September 20, 2024

Re: Powell Amenity Center and Pool

This department has reviewed the plans you submitted for the Powell swimming pool to be constructed at 212 Perseus St., Lillington. This plan review was conducted in accordance with the current North Carolina Rules Governing Public Swimming Pools (15A NCAC 18A .2500).

The plans are not approved as drawn. The following items need to be addressed:

SP3.0

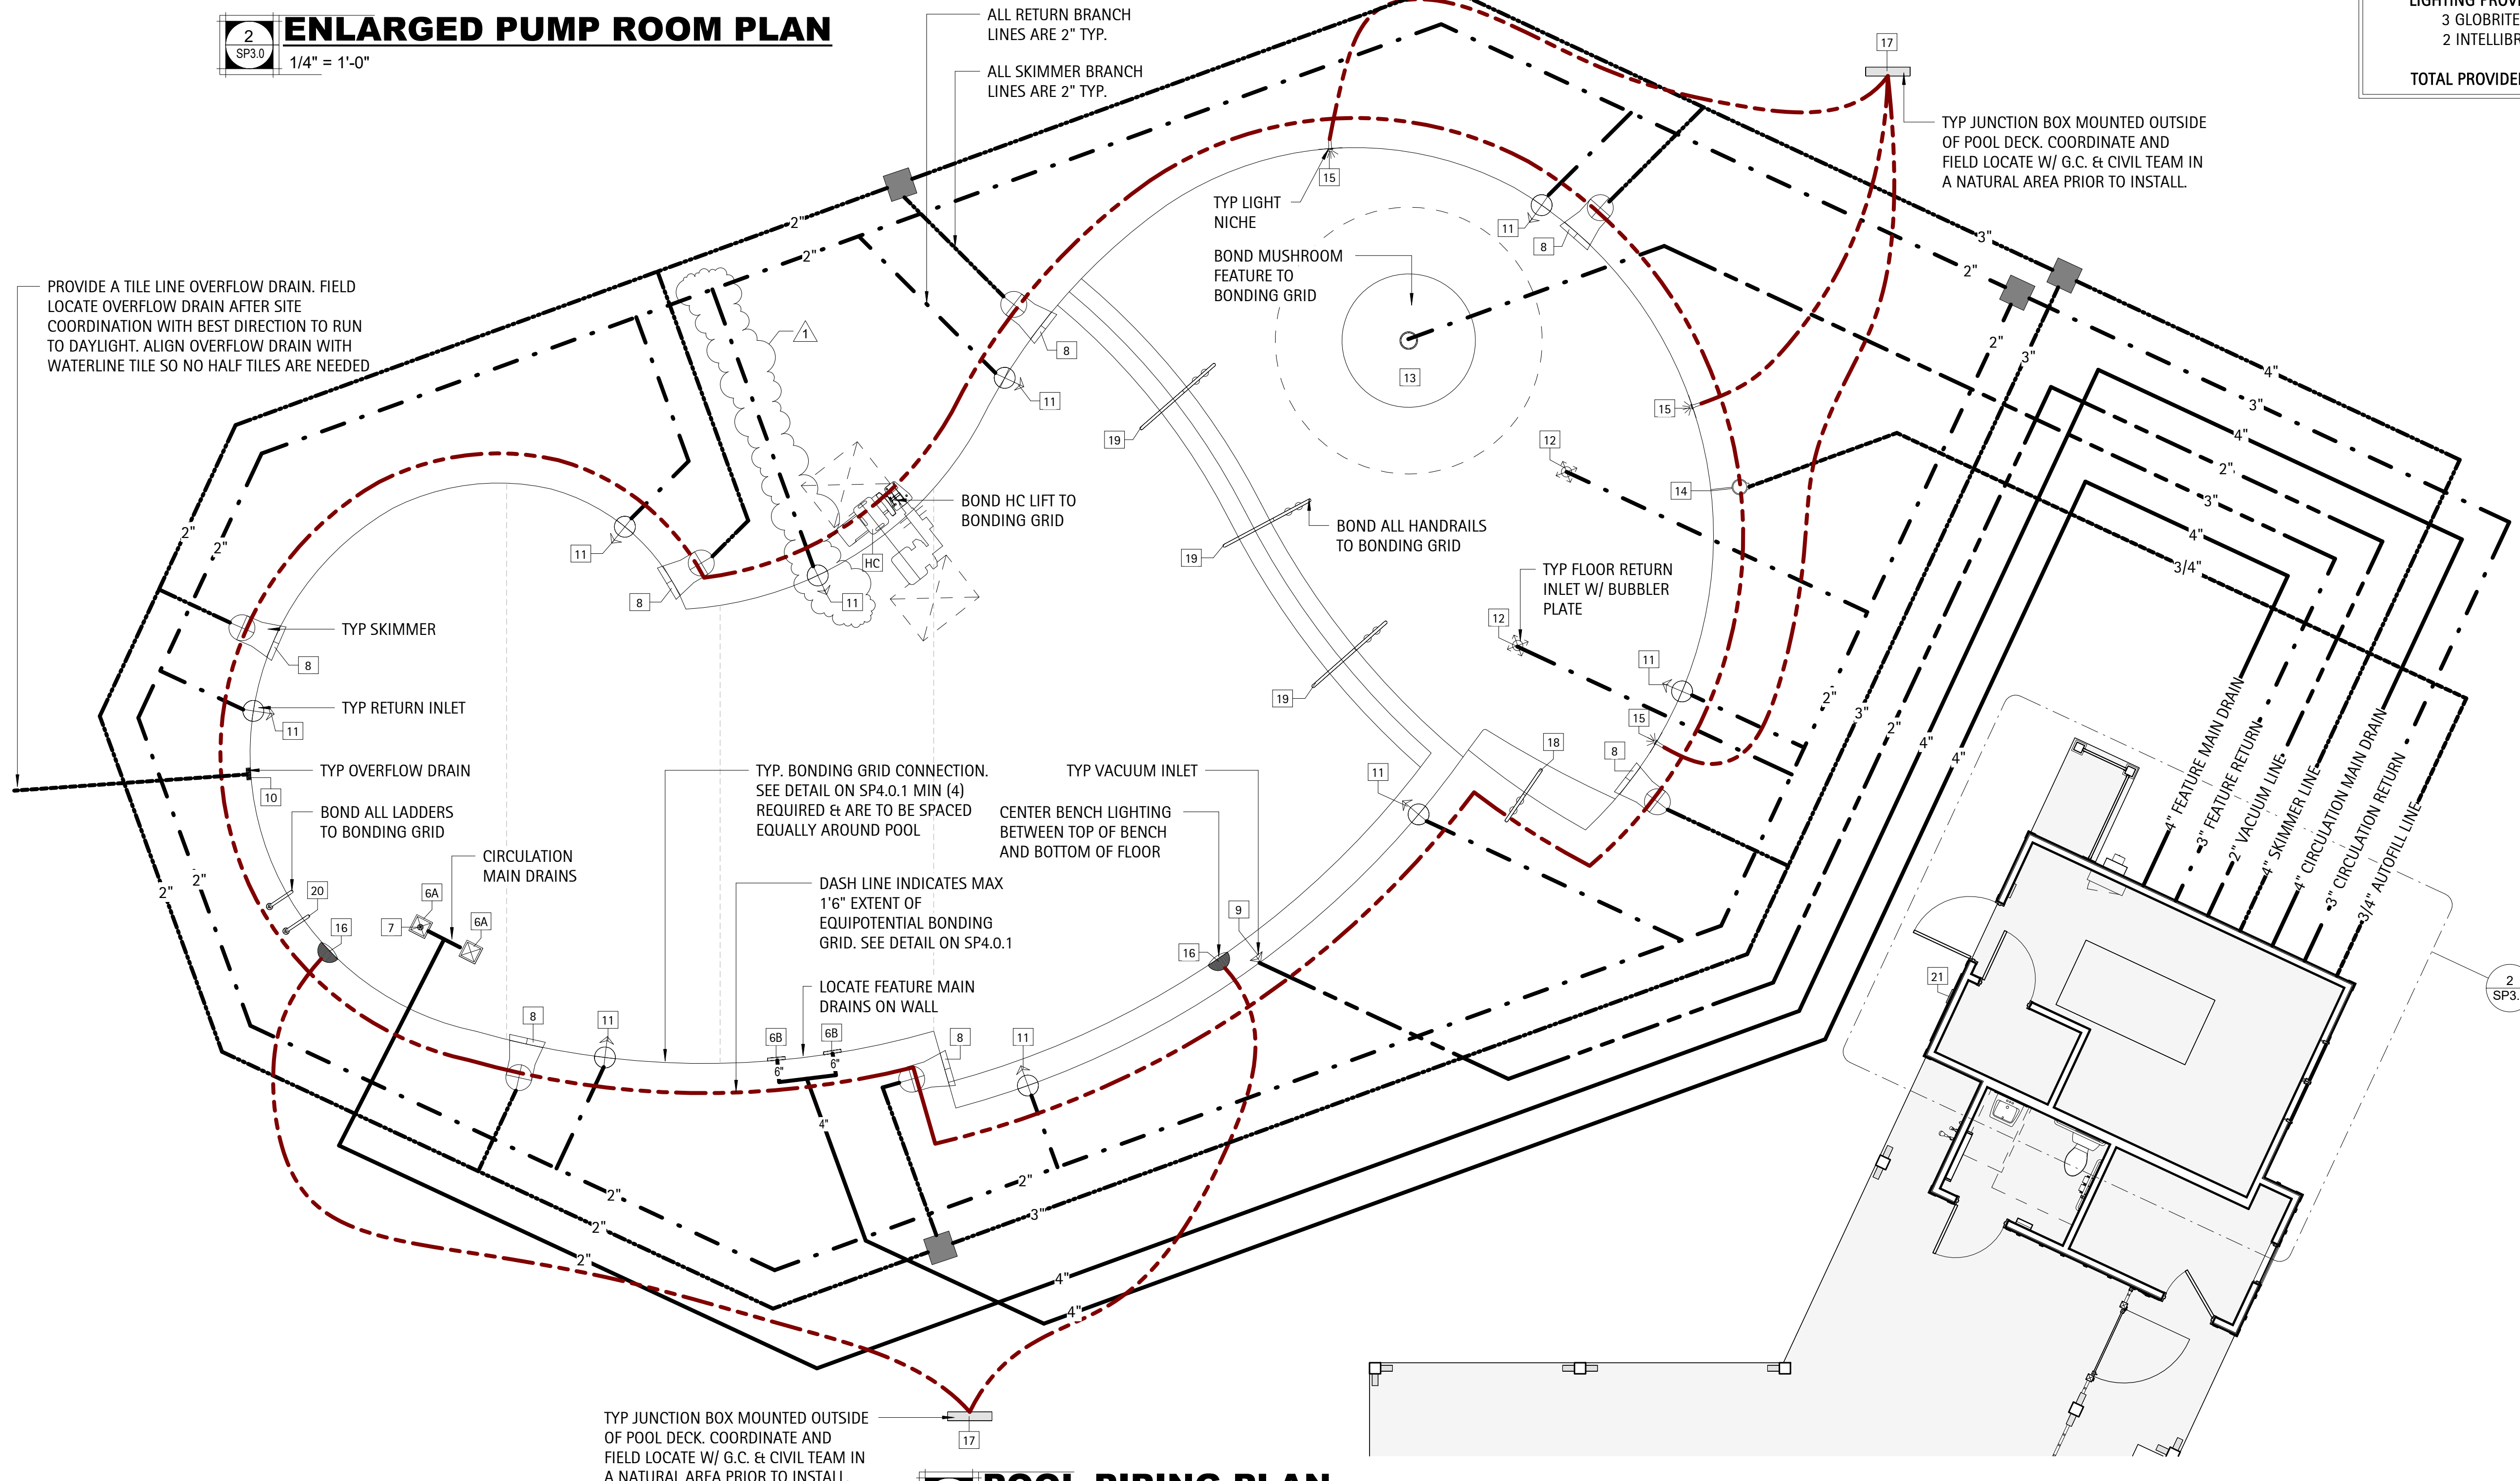
- Items noted on letter submitted with plans are approved but plans shall be updated to show changes prior to approval and release for construction.
- An inlet located to the left of the handicap lift chair as viewed from above, is shown connecting to the suction piping on page SP3.0, piping and electrical diagram.
- The flow meter specified appears to be undersized. The design flow rate of 190 gpm would be 275 gpm at 1.5x. The specified flow meter is rated for up to 240 gpm.
